City of Portland, Maine - Building or Use Permit Application

Permit No: 04-0456	PERMIT ISSUED Issue Date: MAY 19 2004	BL: 392 A007001
-----------------------	---	--------------------

Location of Construction: 140 Hope Ave (Lot #7)		Owner Name: Shaw Larry R &	Owner Address: 23 Longwoods Rd CITY OF PORTLAND	Phone: 207-780-6156
Business Name: n/a		Contractor Name: Longwood Assoc.	Contractor Address: Portland	Phone: 2077806156
Lessee/Buyer's Name n/a		Phone: n/a	Permit Type: Single Family	Zone: R2
Past Use: Vacant	Proposed Use: Build New 28' x 38' Single Family with 28' x 28' garage.		Permit Fee: \$1,806.00	Cost of Work: \$190,000.00
Proposed Project Description: Build New 28' x 38' Single Family with 28' x 28' garage.			CEO District: 5	
		FIRE DEPT: N/A Signature: [Signature]	INSPECTION: Use Group R-3 Type SB BOCA 1999 Signature: [Signature]	
Action: <input type="checkbox"/> Approved <input type="checkbox"/> Approved w/Conditions <input checked="" type="checkbox"/> Denied				
Signature:			Date:

Proposed Use: Build New 28' x 38' Single Family with 28' x 28' garage and breezeway.	Proposed Project Description: Build New 28' x 38' Single Family with 28' x 28' garage and breezeway.
--	-

140 Hope  
 140 Hope  
 HOPE AVE. PORTLAND  
 FLOOR PLANS

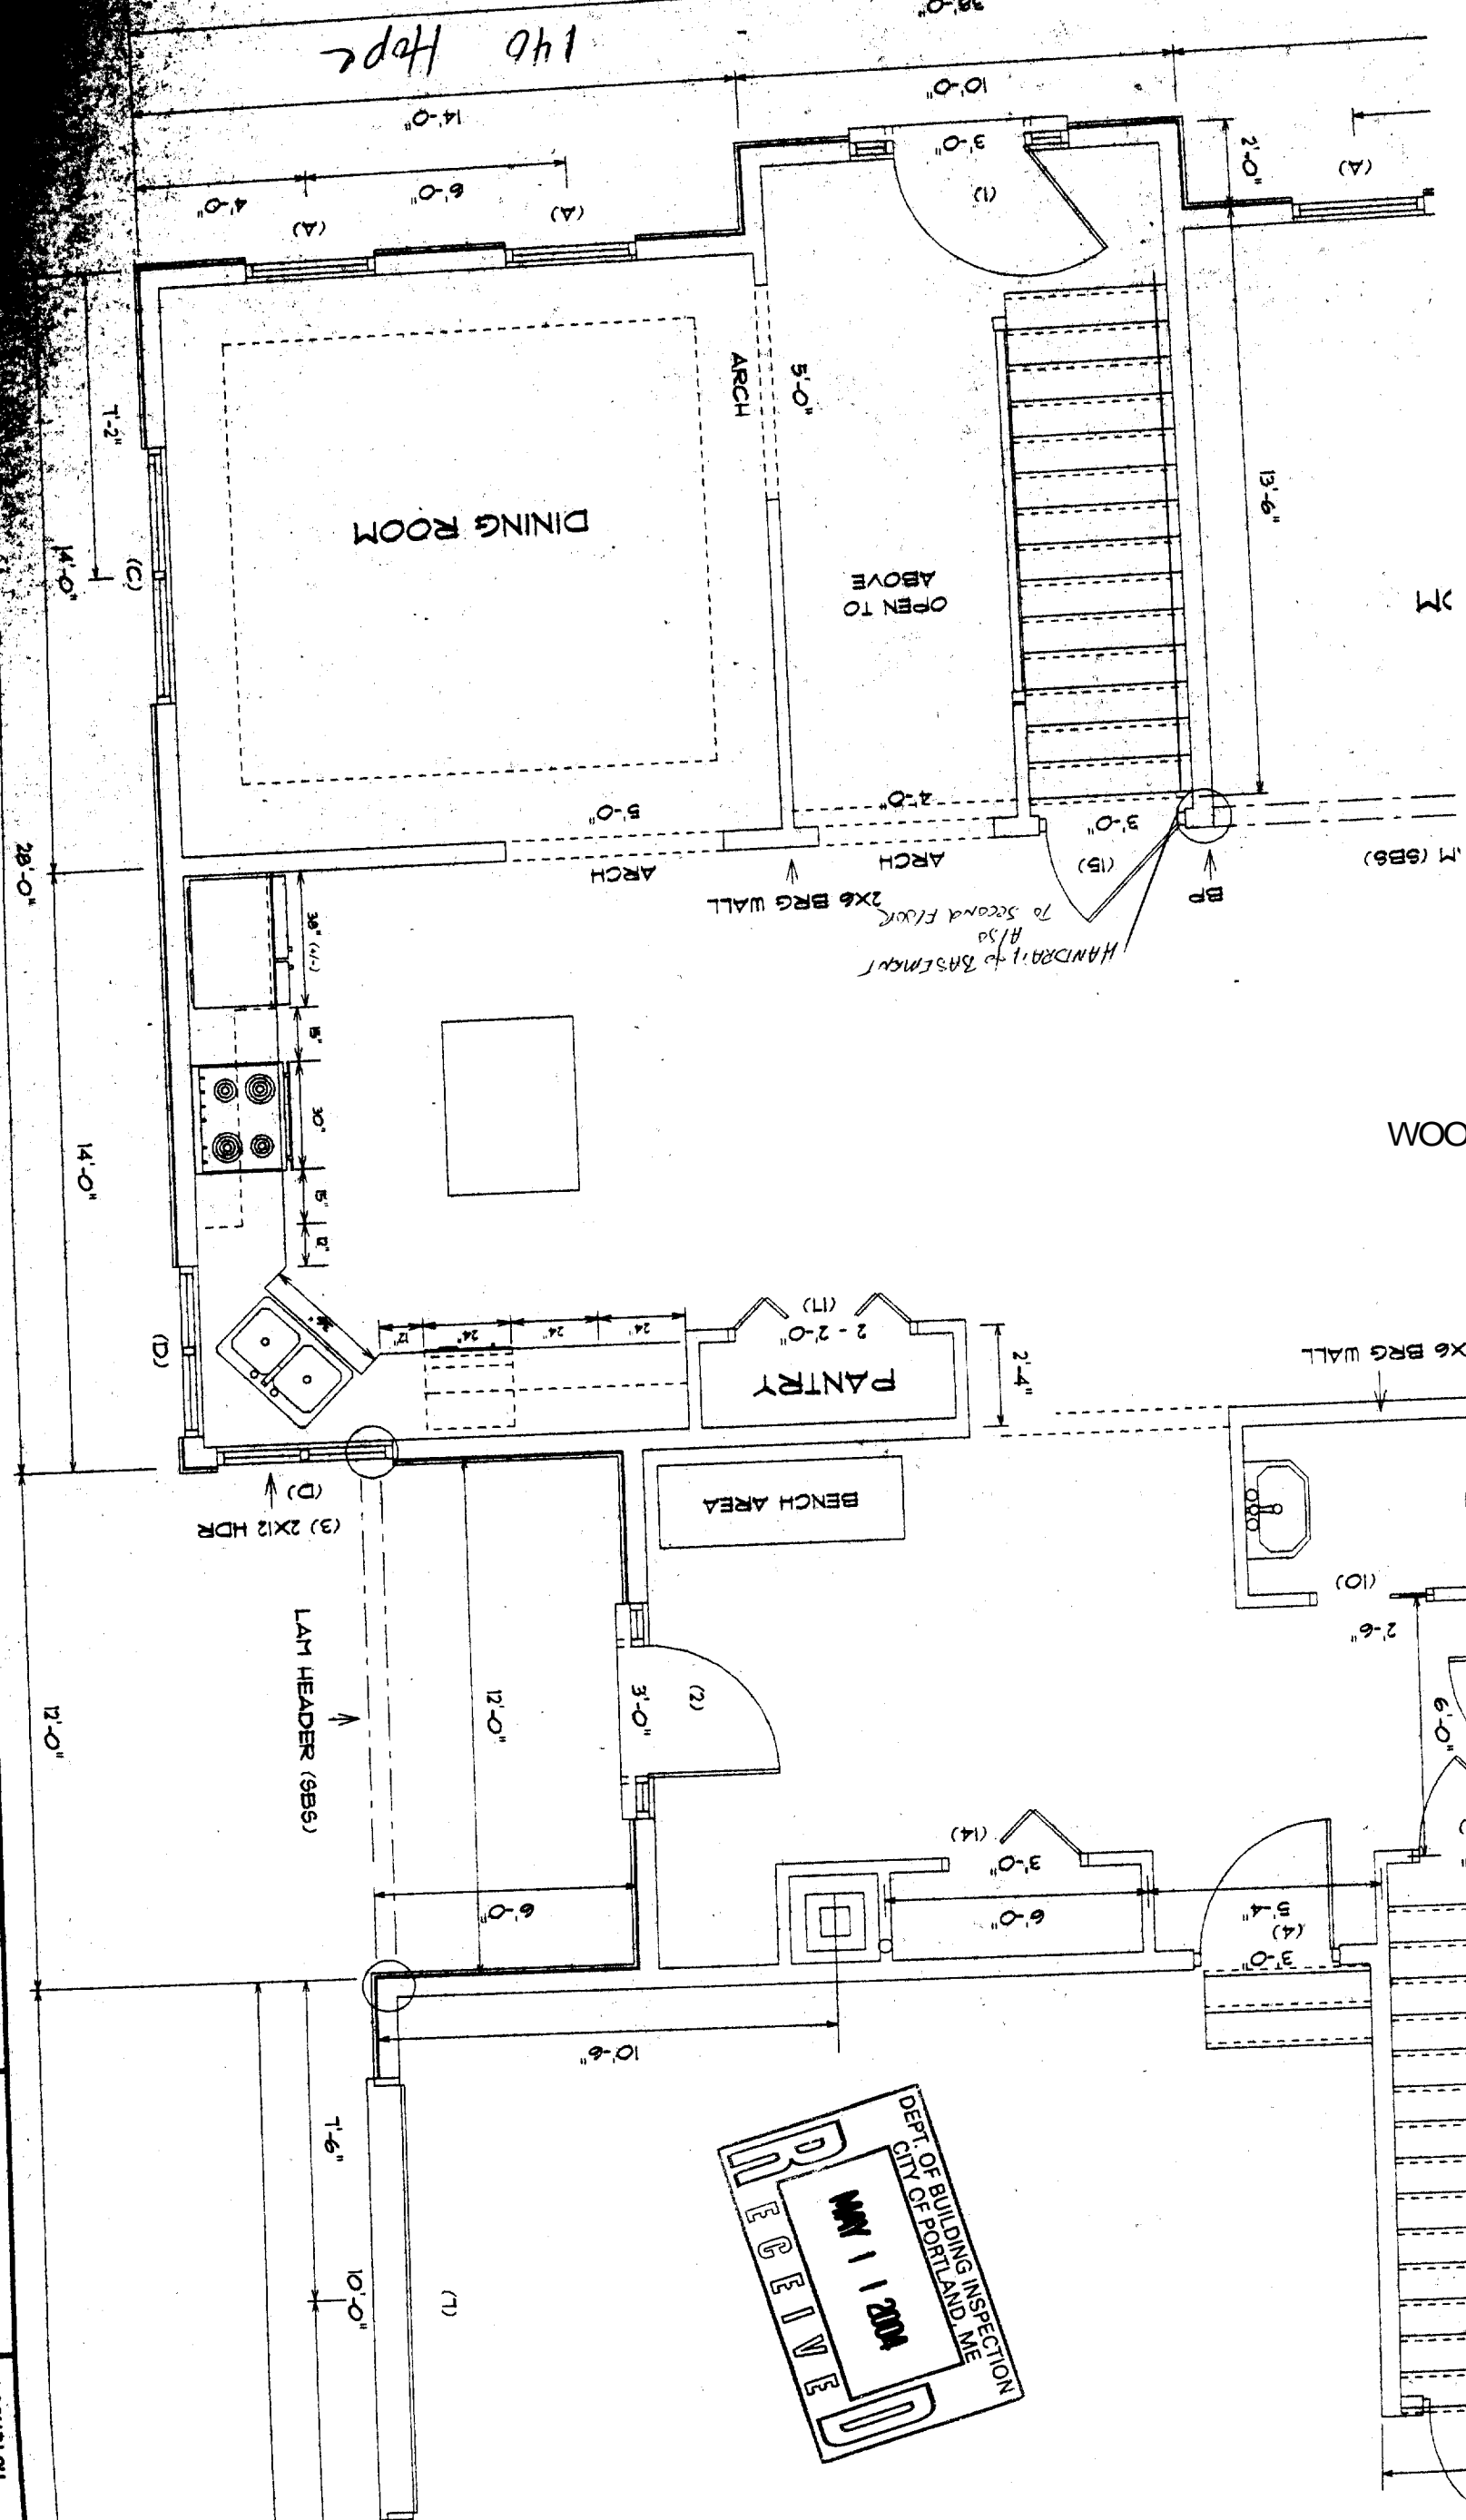
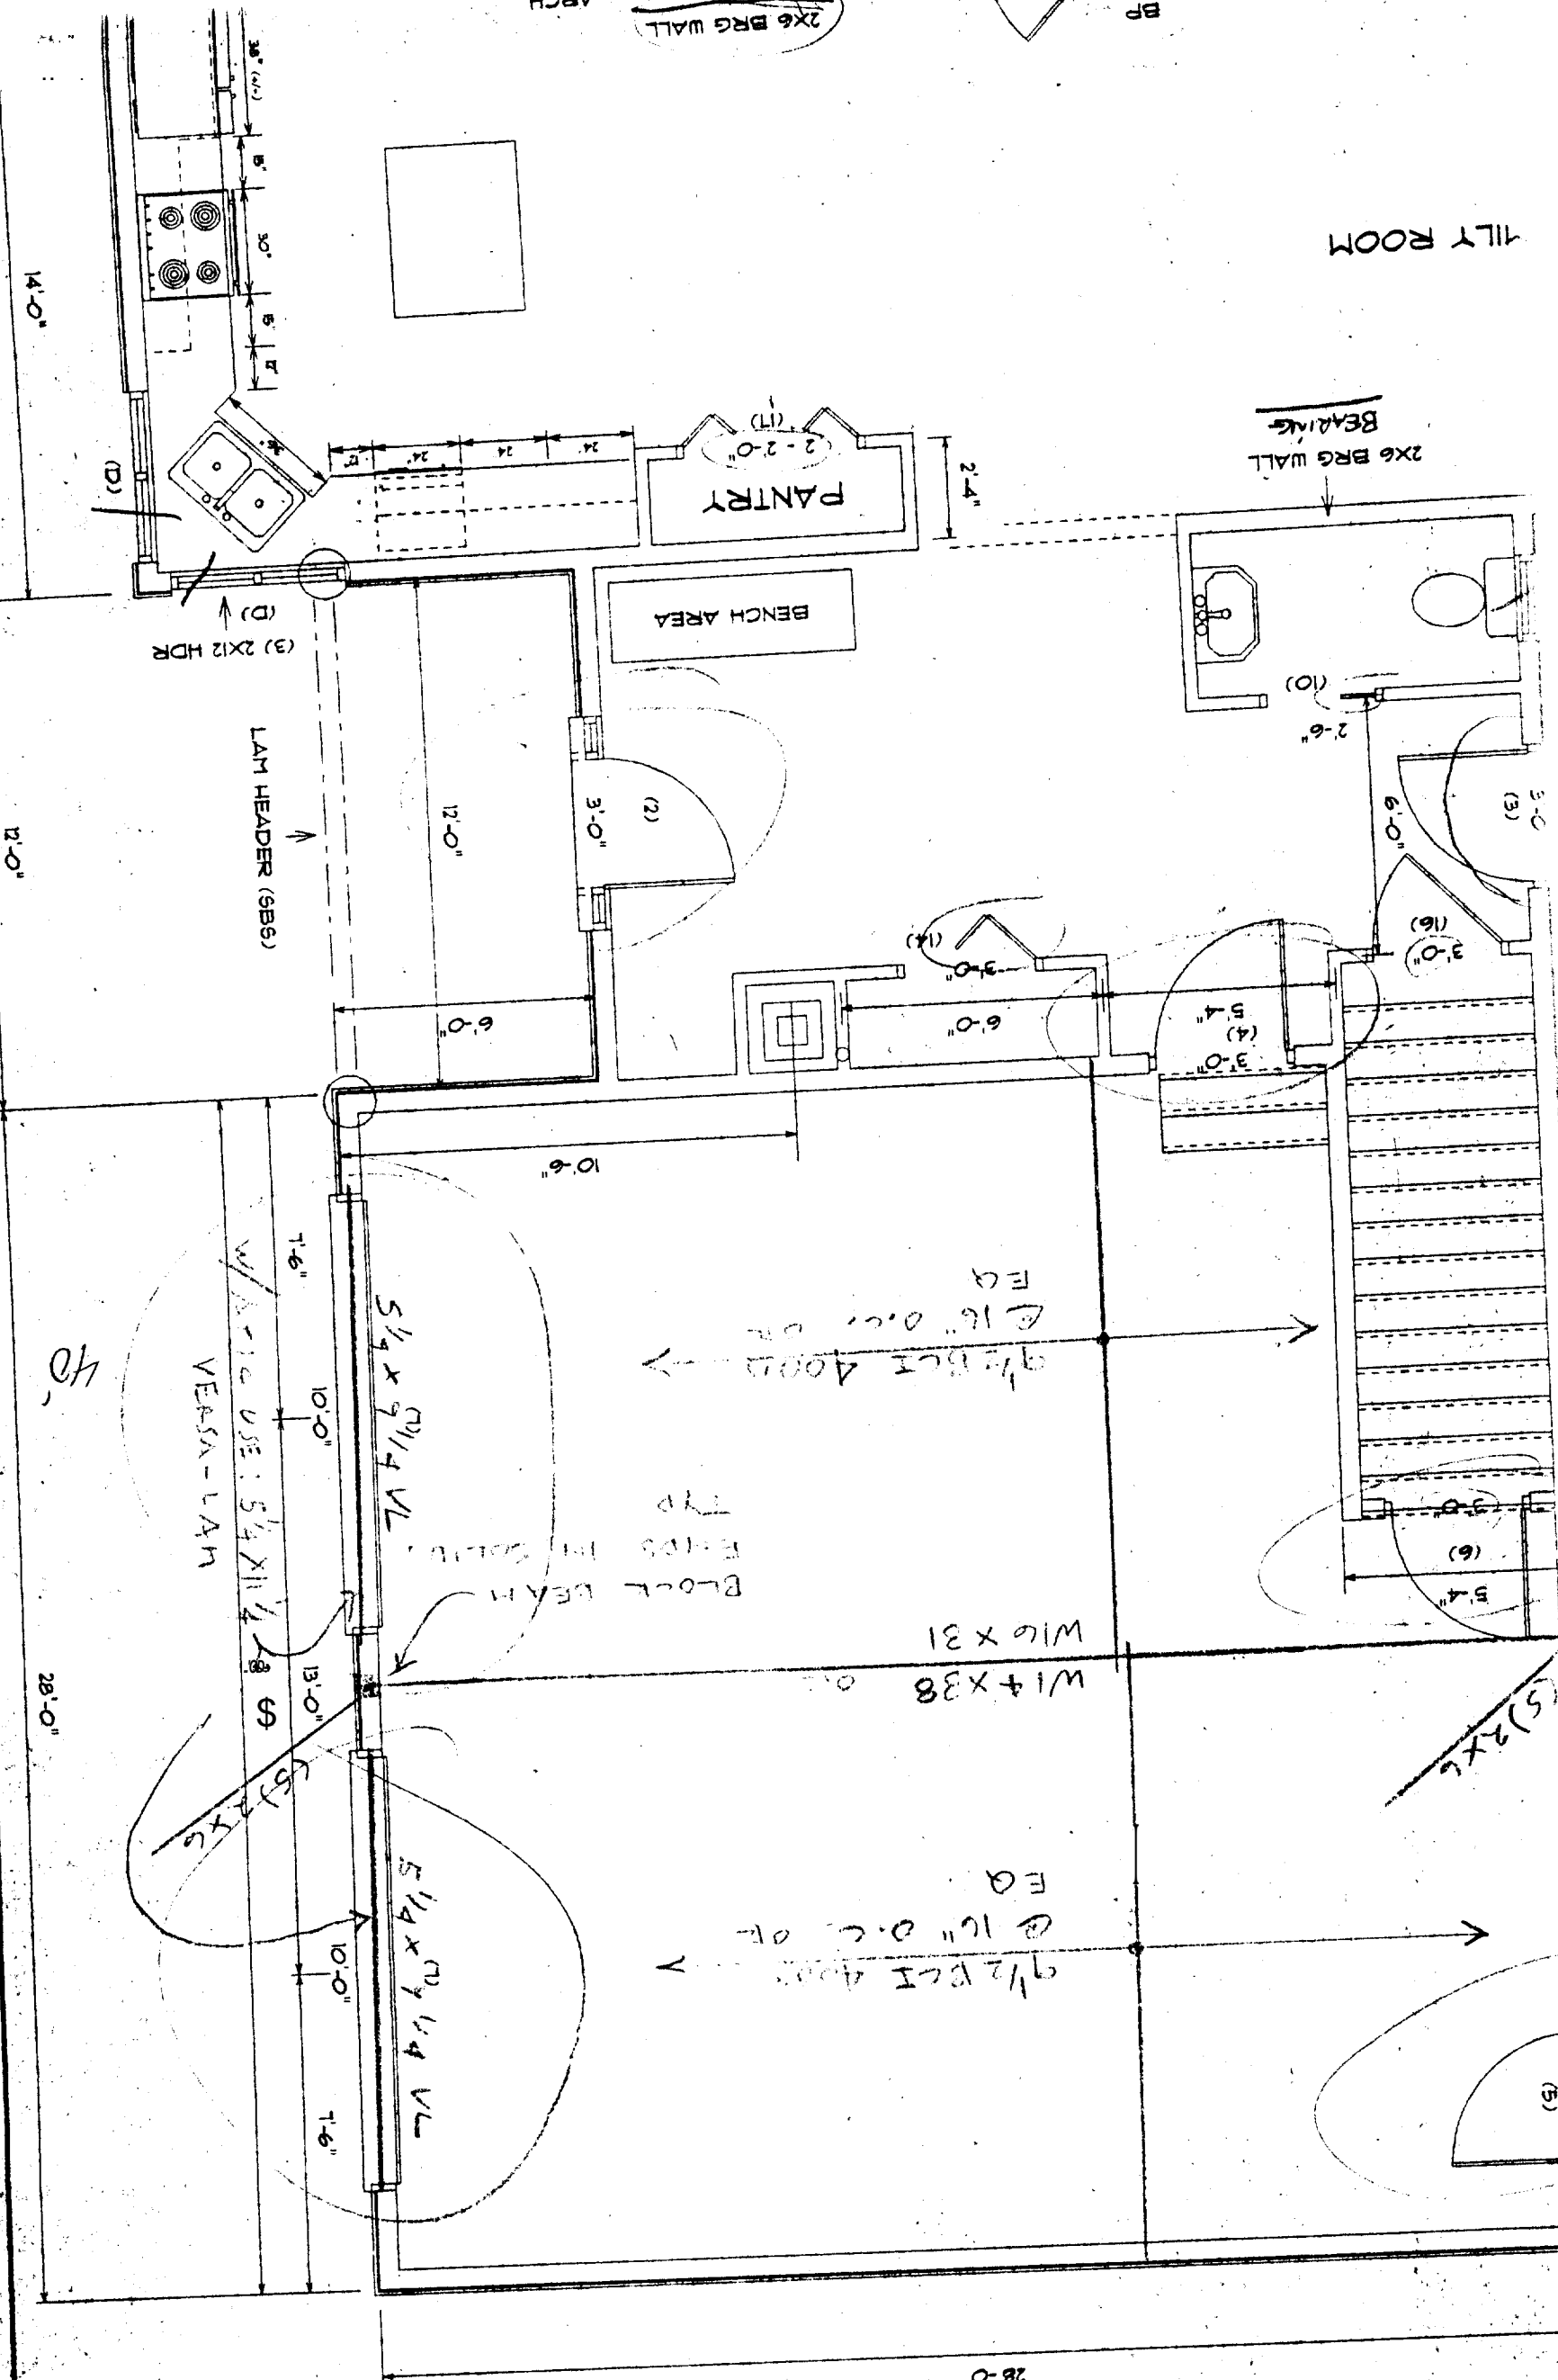
Soil type/Presumptive Load Value (Table 401.4.1)	Component	Plan Reviewer	Inspection/Date/Findings
STRUCTURAL Footing Dimensions/Depth (Table 403.1.1 & 403.1.1(1), Section 403.1.2)	OK	OK OK	
Foundation Drainage Dampproofing (Section 406)	OK	Diarrage w/ 2x4 brif- get Short	
Ventilation (Section 409.1) Crawls Space ONLY	N/A	N/A	
Anchor Bolts/Straps (Section 403.1.4)	N/A	Shows - 8'oc - Code is 6'oc -	5/12/04 - OK
Lally Column Type, Spacing and footing sizes (Table 502.3.4(2))	OK		
Built-Up Wood Center Girder Dimension/Type (Table 503.3.4(2))		3-2x12's - OK largest span is 6'-10" Footing 512". 24"x24" - Need 26"x26"	
Sill/Band Joist Type & Dimesions		2x6 - OK	
First Floor Joist Species Dimensions and Spacing (Table 503.3.1(1) & Table 503.3.2(1))	OK	Shows - 2x10's 16"oc OK	
Second Floor Joist Species Dimensions and Spacing Table(503.3.1(1) & Table 503.3.2(1))		- Garage - TJI's - size ?	40's 9 1/2" BCZ'S OK - 14' span

<p>Attic or additional Floor Joist Species Dimensions and Spacing (Table 802.4.2 or 503.3.1(1) & Table 503.3.2(1))</p>	<p>Truss</p>	
<p>Roof Rafter; Pitch, Span, Spacing & Dimension (Table 802.3.2(7))</p>	<p>Tresses } Need specs</p>	
<p>Sheathing; Floor, Wall and roof (Table 503.2.1(1))</p>	<p>OK</p>	
<p>Fastener Schedule (Table 602.3(1) & (2))</p>	<p>Not shown</p>	
<p>Private Garage Section 309 and Section 407 1999 BOCA) Living Space ? Yes</p>	<p>Not shown where</p>	
<p>Fire separation</p>	<p>OK shows 1 hour</p>	
<p>Fire rating of doors to living space Door Sill elevation (407.5 BOCA)</p>	<p>Not noted as egress</p>	
<p>Egress Windows (Section 310)</p>	<p>OK</p>	
<p>Roof Covering (Chapter 9)</p>	<p>OK</p>	
<p>Safety Glazing (Section 308)</p>	<p>OK</p>	
<p>Attic Access (BOCA 1211.1)</p>	<p>Shows 21"x36" - Min is 22"x30"</p>	
<p>Draft Stopping around chimney</p>	<p>Clearances + draft stopping -</p>	<p>Not shown</p>

Need for
all windows + doors

Header Schedule	Not shown	
Type of Heating System	OK	
Stairs		
Number of Stairways		
Interior 2		
Exterior 2		
Treads and Risers - OK - not ok - Exterior - Not shown (Section 314)		
Width 3' - OK		
Headroom OK		
Guardrails and Handrails (Section 315)	Not shown	
Smoke Detectors Location and type/Interconnected	Not shown	
Plan Reviewer Signature

13 Steel Beam - need stamped by engineer.

14 Need all Laminates spec'd out.

1. Anchor bolts Noted 6' OC
2. Footing Size - 12' X 24" X 24"
3. GARAGE TJI's - W140 9 1/2 X 14 16" OC / 9 1/2 R.M. Board
4. ROOF TRUSS
5. Cement work checked on plan

6. Fastener Schedule / AND Truss Hanger / Steel bolted
7. Noted on plan 5/8 Sheet Rock between breezeway AND GARAGE plus ceiling
8. All bedrooms will have AT LEAST 2 egress means of exit This includes AT LEAST ONE WINDOW OR MORE

9. Noted on plan Attic Access to be INCREASED to AT LEAST 22" X 30"
10. CLEARANCE AROUND Chimney MIN 2" ALL THE WAY TO ROOF with Flashing between Floors

11. Headers will be 2x10 in ALL load bearing openings
12. Outside will be granite steps (2 steps total) - 7 3/4" R 10" T
13. Noted on plan HANDRAIL to second floor

14. Noted on plan smoke detector in ALL bedrooms, kitchen living room AREA, basement, breezeway
15. Steel W16 X 26 28 long
16. Subfloors will be Advantech 3/4 TG / 11 AM ~~3 1/4" X 15'~~
 Exterior will be 7/16 OSB 7 X 14 VL
 Roof will be Advantech 5/8 TG OR W8 X 28
